Application Reference: 6/2017/1486/VAR

Proposed development at: Unit 13 Peartree Farm Welwyn Garden City AL7 3UW

Proposal: Variation of condition 1 (approved plans) on planning permission
6/2015/1960/FULL.

WEST ELEVATION

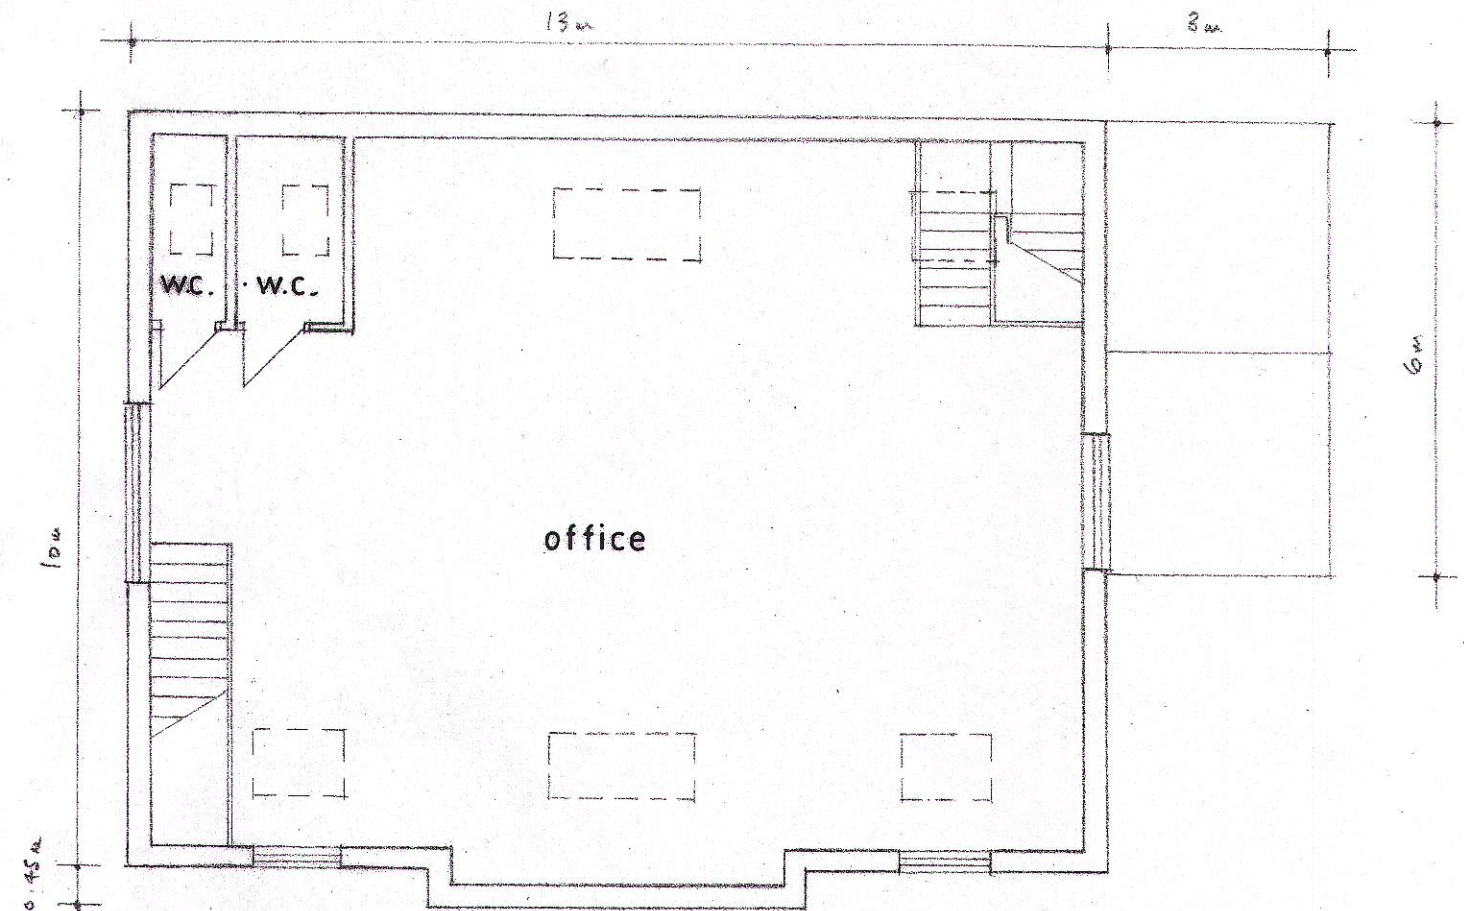
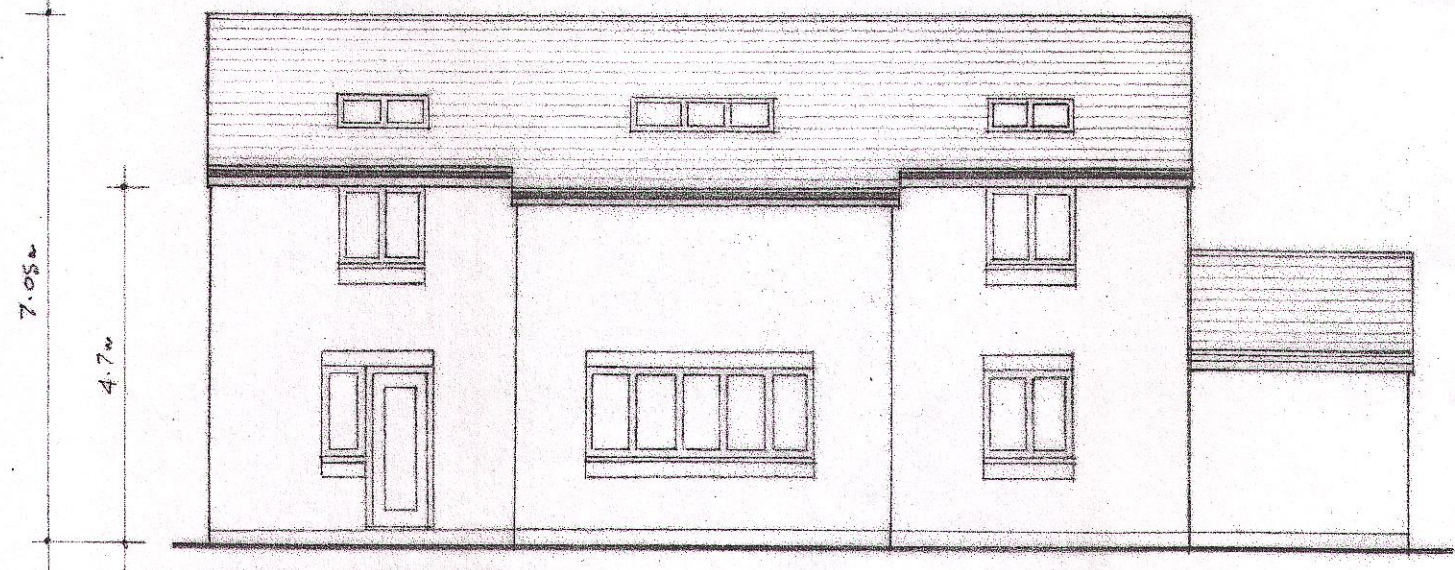
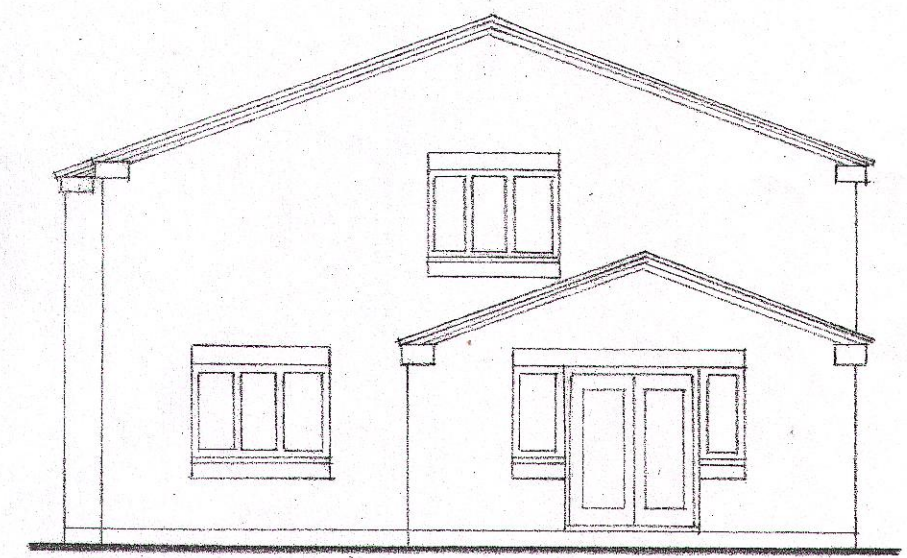
The original plan was for a one and a half storey building with a pitched roof. I did not object at the time as I felt this would be in keeping with the units in Peartree Farm and the local residential housing. This variation has taken on the appearance of a two storey building and is not sympathetic to the surrounding buildings and will appear dominant on the landscape.

SITE/ROOF PLAN

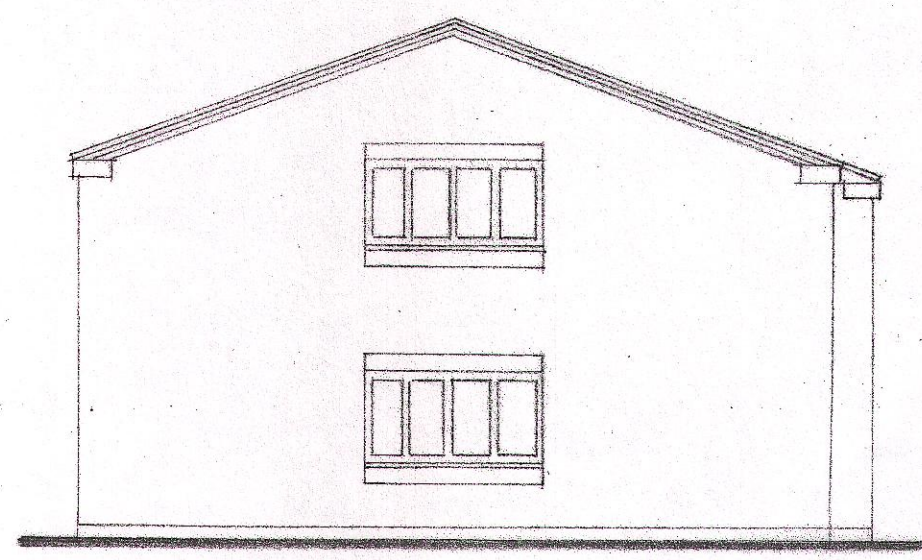
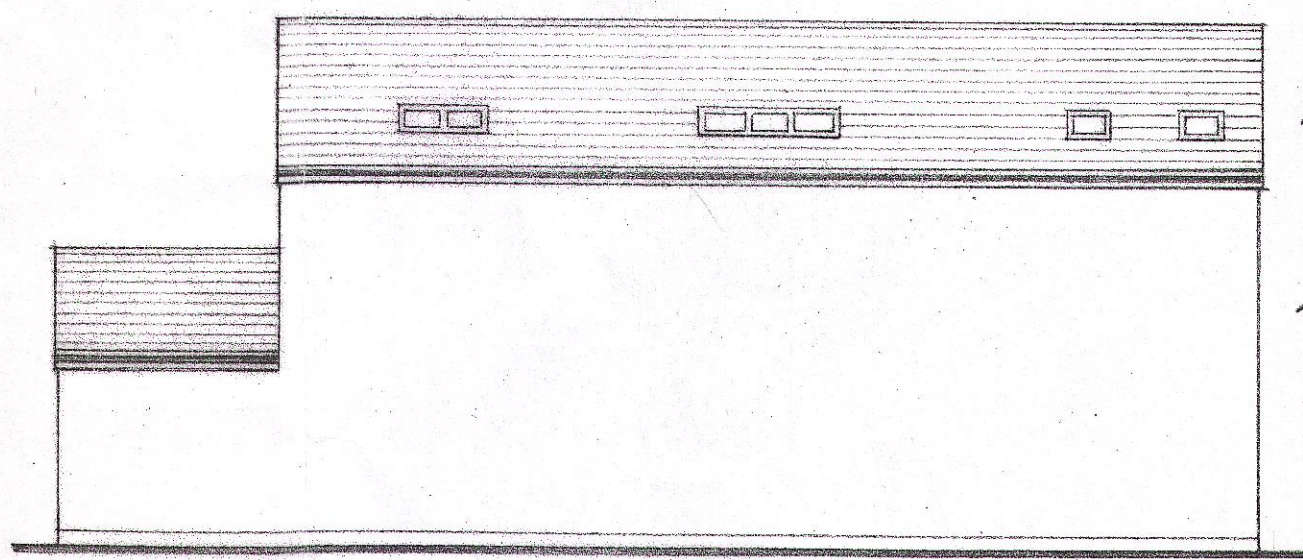
In the original proposal the view from my garden would have been that of a pitched roof with very little loss of amenity. In the revised proposal my view will be that of a brick wall with a flattened roof causing loss of amenity.

There are several trees (maintained by the council) on the boundary of my property and that of No. 76 Peartree Lane and the east boundary of the proposed building which are not shown on the plans nor is there a tree report to accompany the application. I am concerned that these trees may be damaged during the construction or their roots may be affected when the foundations are dug.

I also note from the plans that there is a window at first floor height to the north elevation. Whilst the existing trees screen the back of my garden from Peartree Farm when they are in leaf during the summer months, during the winter when the leaves have fallen this window will afford a view of my garden and will deny me my privacy.
